Subject: RE: Planning Consultation on: AB/75/20/PL

Application No: AB/75/20/PL

Site Address: 55-57 High Street Arundel BN18 9AJ

Description of Works: Conversion of existing mixed use space to 1 No. 1- bedroom flat. This application affects the character & appearance of the Arundel Conservation Area & affects the setting of a Listed Building.

## Proposed Ground Floor Plan

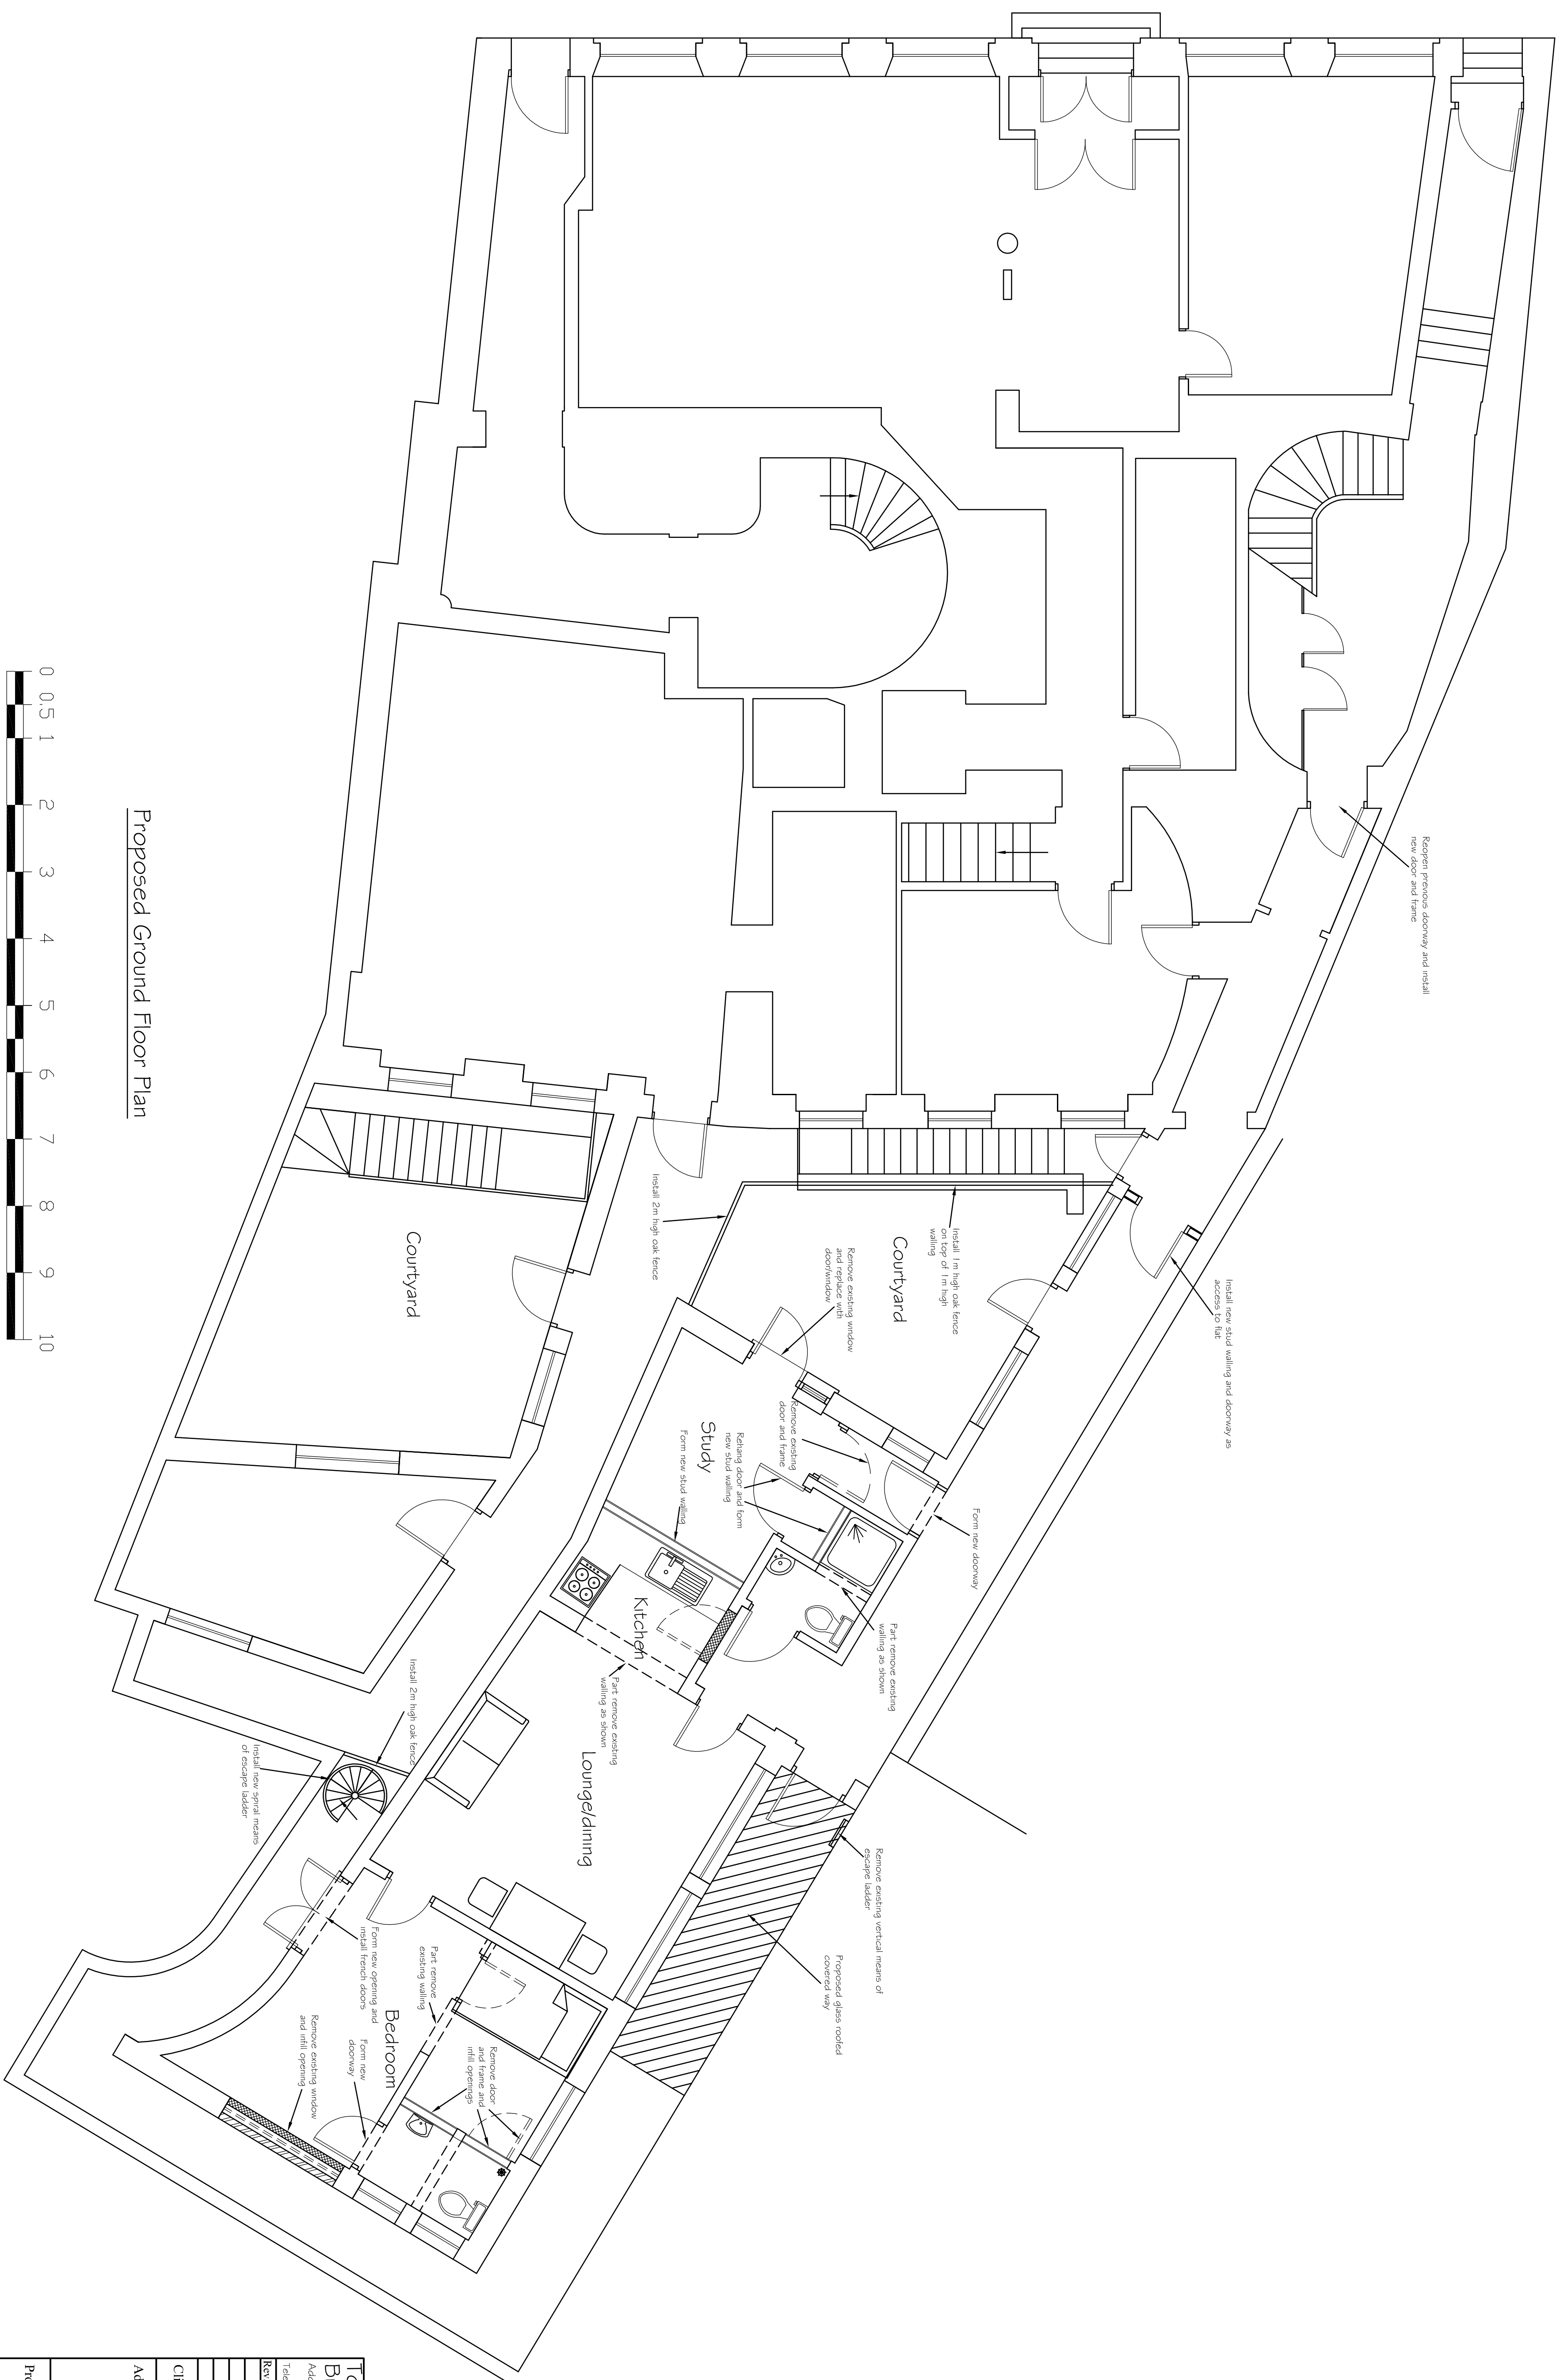
One of the pictures shows an air conditioning unit in very close proximity and pointing directly towards the windows of the planned dwelling. This has the potential to negatively affect the residential amenity of any future occupiers by causing noise and vibration issues. However, I see from the plans that it is proposed to put a glass roof over this area. I would therefore need to know what this air conditioning unit serves and if it is to be left in place, totally removed, replaced or moved somewhere else and if so where to before I would be confident that there will not be a noise issue. I would ask that the applicant provides answers to the above issues so that I can make a full assessment. Without this information I would have to consider objecting to the application on noise grounds or requesting a noise assessment and potentially sound insulation works in order to ensure that any future occupiers are not disturbed by noise from the unit.
